Please ask for: Nicola Moore
Email: nicola.moore@arun.gov.uk
Telephone: Ext 37944
Our Ref: AB/19/22/HH
Your Ref:
Date: 28th February 2022

Application for Planning Permission for Works or Extension to a Dwelling

Development: Proposed side extension, loft conversion, changes to external finishes, together with internal alterations and all associated drainage works
Location: 39 Priory Road Arundel BN18 9ET

LOFT PLAN / ROOF PLAN
AS PROPOSED
1:50

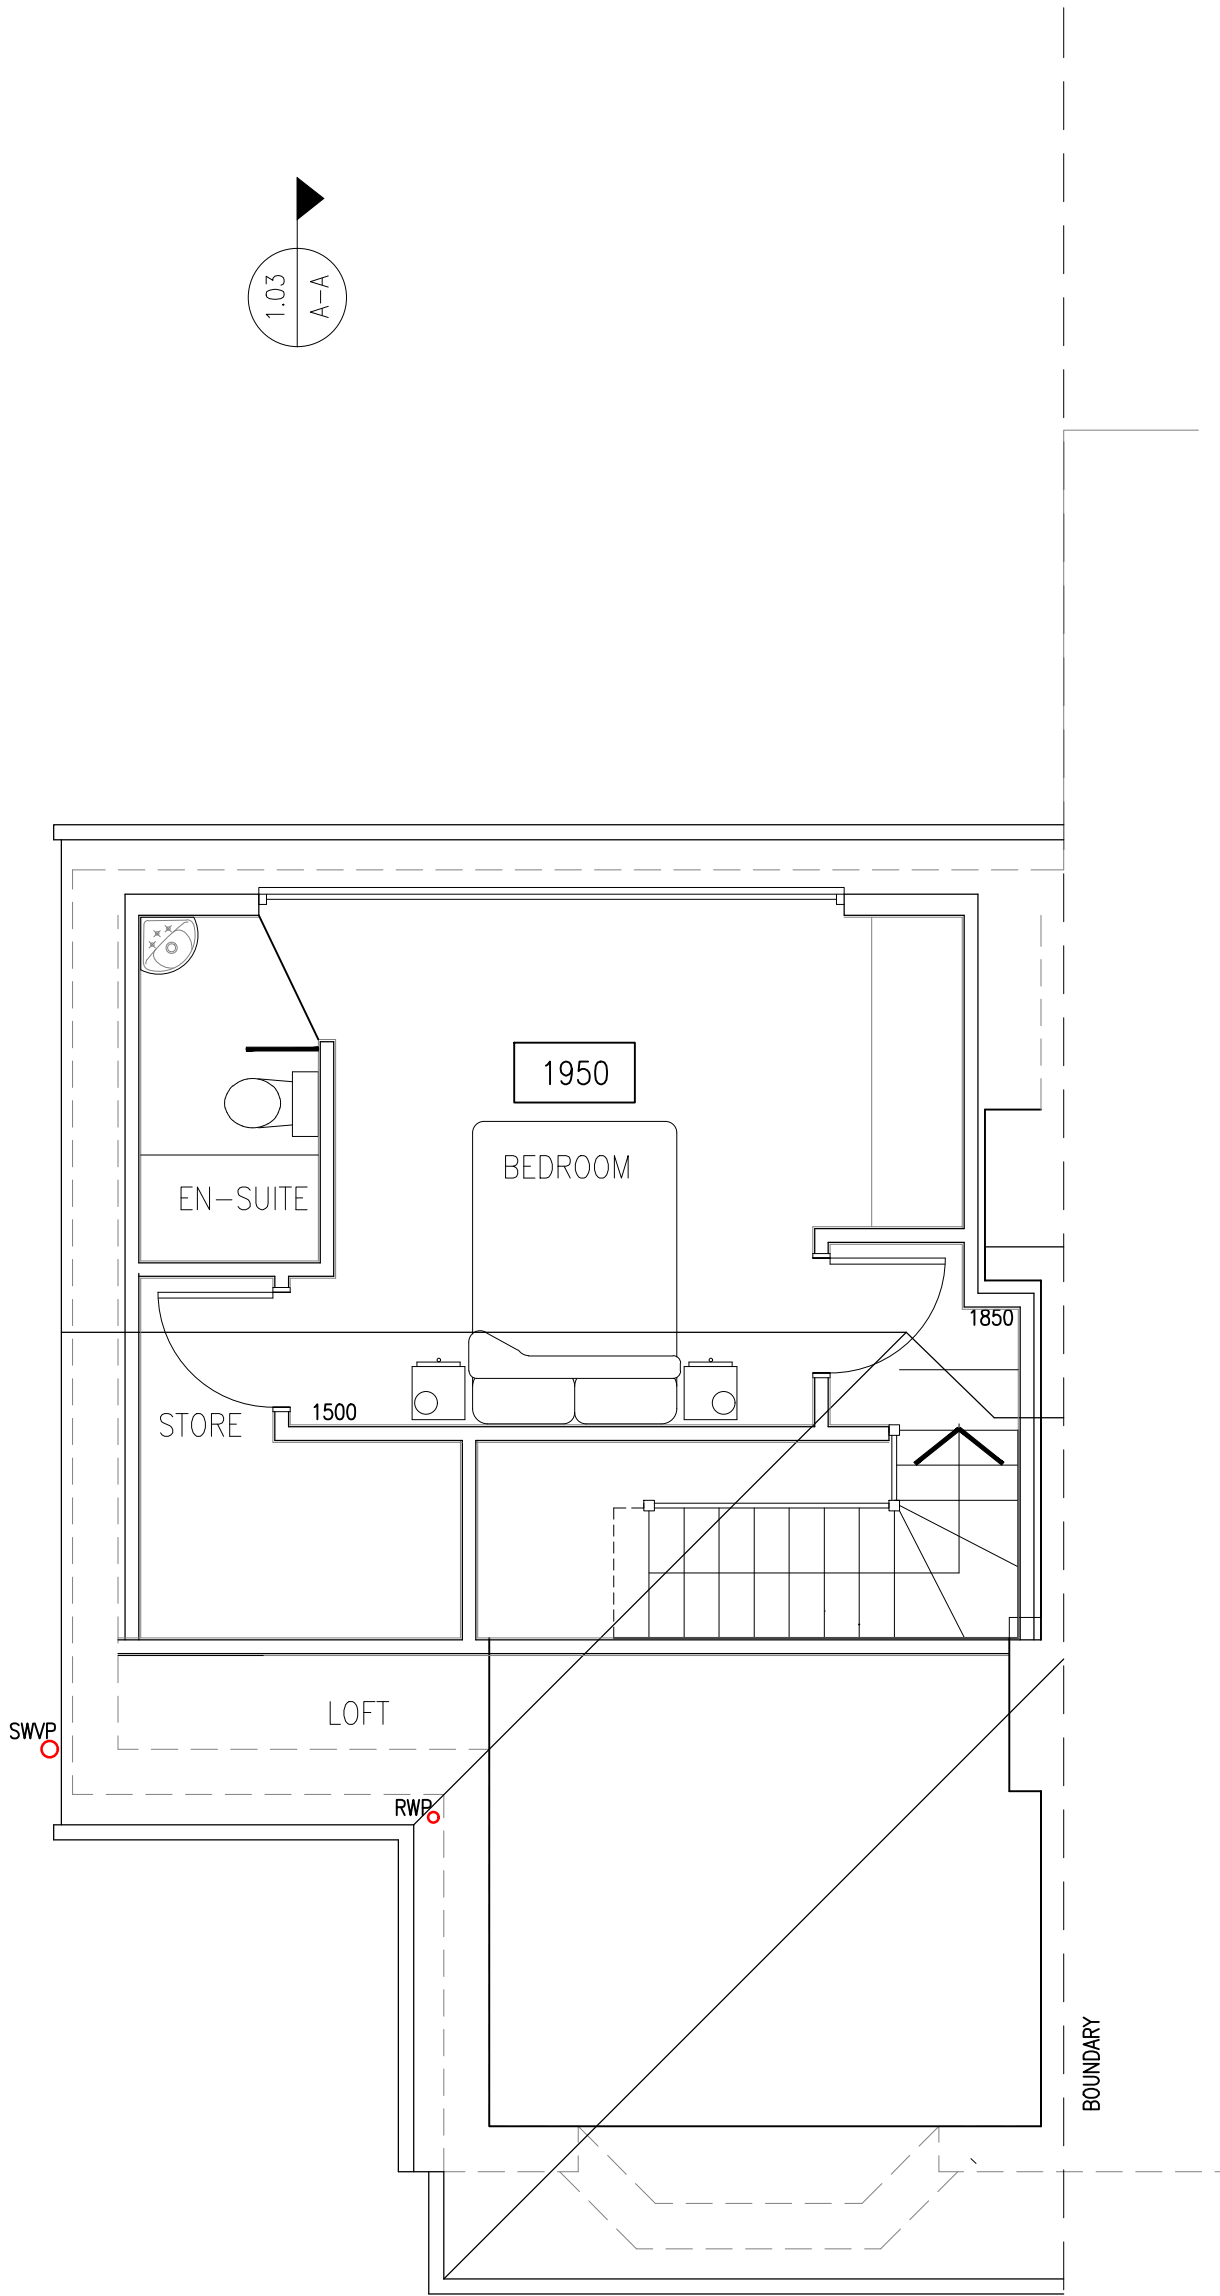
Roof Plan

Please submit electronic plans showing the existing and proposed roof plan. Please refer to the Validation Requirements List for further details.
